WEST SUSSEX COUNTY COUNCIL CONSULTATION

TO:	Arun District Council - FAO: Simon Davis
FROM:	WSCC - Highways Authority
DATE:	10 June 2021
LOCATION:	26 Burnham Avenue, Bognor Regis, PO21 2JU
SUBJECT:	BR/129/21/OUT Outline application with all matters reserved for 10 new dwellings consisting of 1 No. 1 bed property, 8 No. 2 bed properties and 1 No. 4 bed property with associated services, landscaping, car parking & amenity (resubmission following BR/190/20/OUT).
RECOMMENDATION:	Advice

SITE PLAN (PROPOSED) 1:200

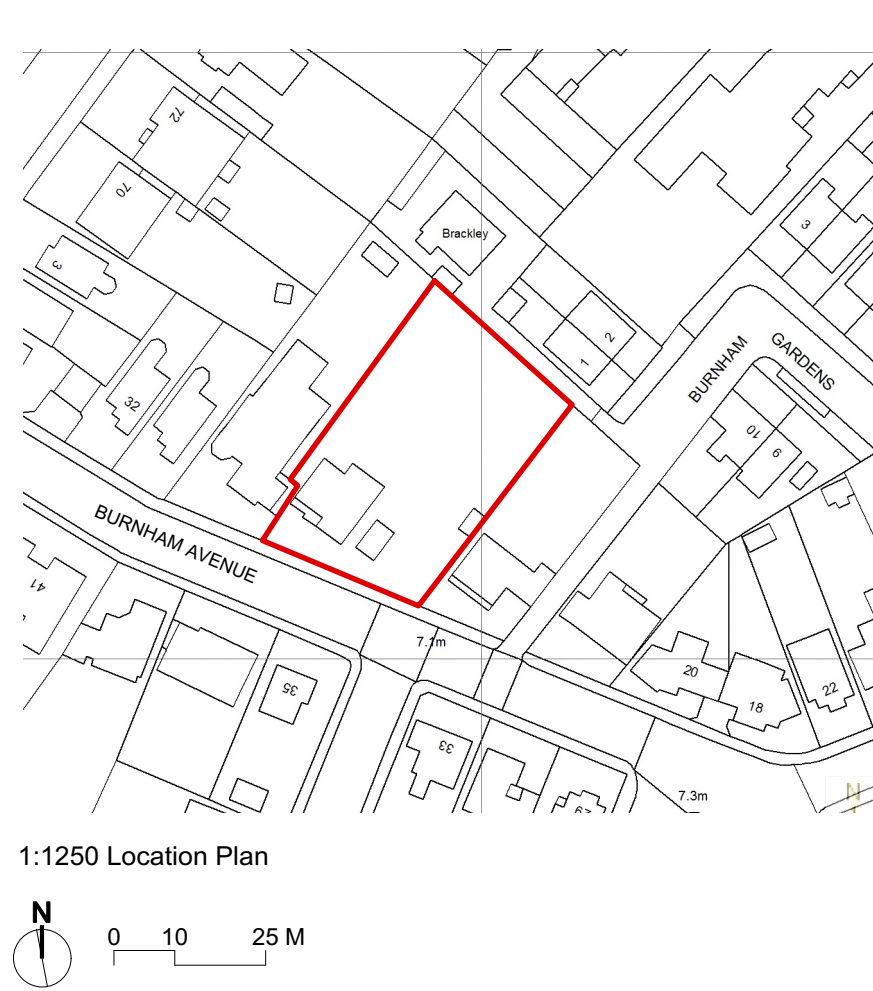
There are no parking restrictions on Burnham Avenue and on-street parking takes place both sides of the carriageway. The nearby junction with Victoria Drive to the west is protected by double yellow line junction protection markings. The existing dropped kerb would be extended to provide access to a rear parking area and frontage parking. The access route in the site is not wide enough for 2 x cars to pass in opposing directions. Considering the anticipated traffic levels and low speeds the LHA could not raise a highway safety concern to these arrangements. Nevertheless, the applicant may wish to consider widening the access route to improve the arrangements from an amenity point of view. At reserved matters stage it would be useful for the applicant to demonstrate through swept path tracking plans that cars can turn on site.

No objection is raised to the principle of the access however the applicant should be aware that a license to construct the vehicular cross over would need to be obtained from the Arun Area Engineer. It should be noted that a licence at this location may not be granted due to the total crossover width exceeding 6.4m; due to the existing parking pressures and the loss of on-street parking provision for neighbouring residents. It is recommended that the LPA consider the amenity impact of the proposed development should permission be granted. The LHA acknowledge the Area Office's guidelines regards access width. Nevertheless, from a highway safety point of view the LHA could not substantiate grounds to resist the proposal. The potential loss of an on-street parking space would not cause a highway safety reason for refusal.

The DaS refers to a Lambeth methodology parking survey that has been carried out though the LHA cannot find this on the Arun planning portal. This should be provided in support of the application at reserved matters stage.

4-bedroom would require 11 x spaces. The plans indicate total 13 x spaces across the site plus a single garage (0.5 space). Two of the spaces will be unallocated/visitor parking as required by the SPD (20% total units). The LHA are satisfied with the indicated level of parking provision though the applicant may wish to revise the layout to allow for two cars to pass within the site and access, this is considered more of an amenity concern.
